Application no: 21/02496/DISC

Location: Land to The South And Adj To, South Side, Steeple Aston

Local Lead Flood Authority

Objection to Discharge of Condition 5

Test Location: SA1

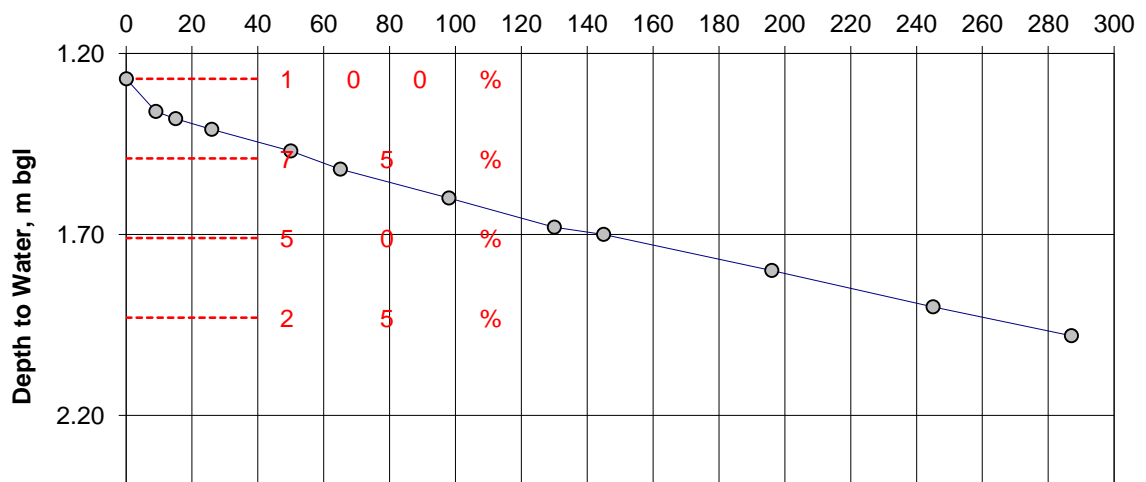
Infiltration testing carried out needs more results to conclude with an accurate rate. Currently, the submitted data only has 1 test for SA1 and 2 tests for SA2. As these two are the preferred location of soakaways, we will need to see at least 2 tests at these locations.
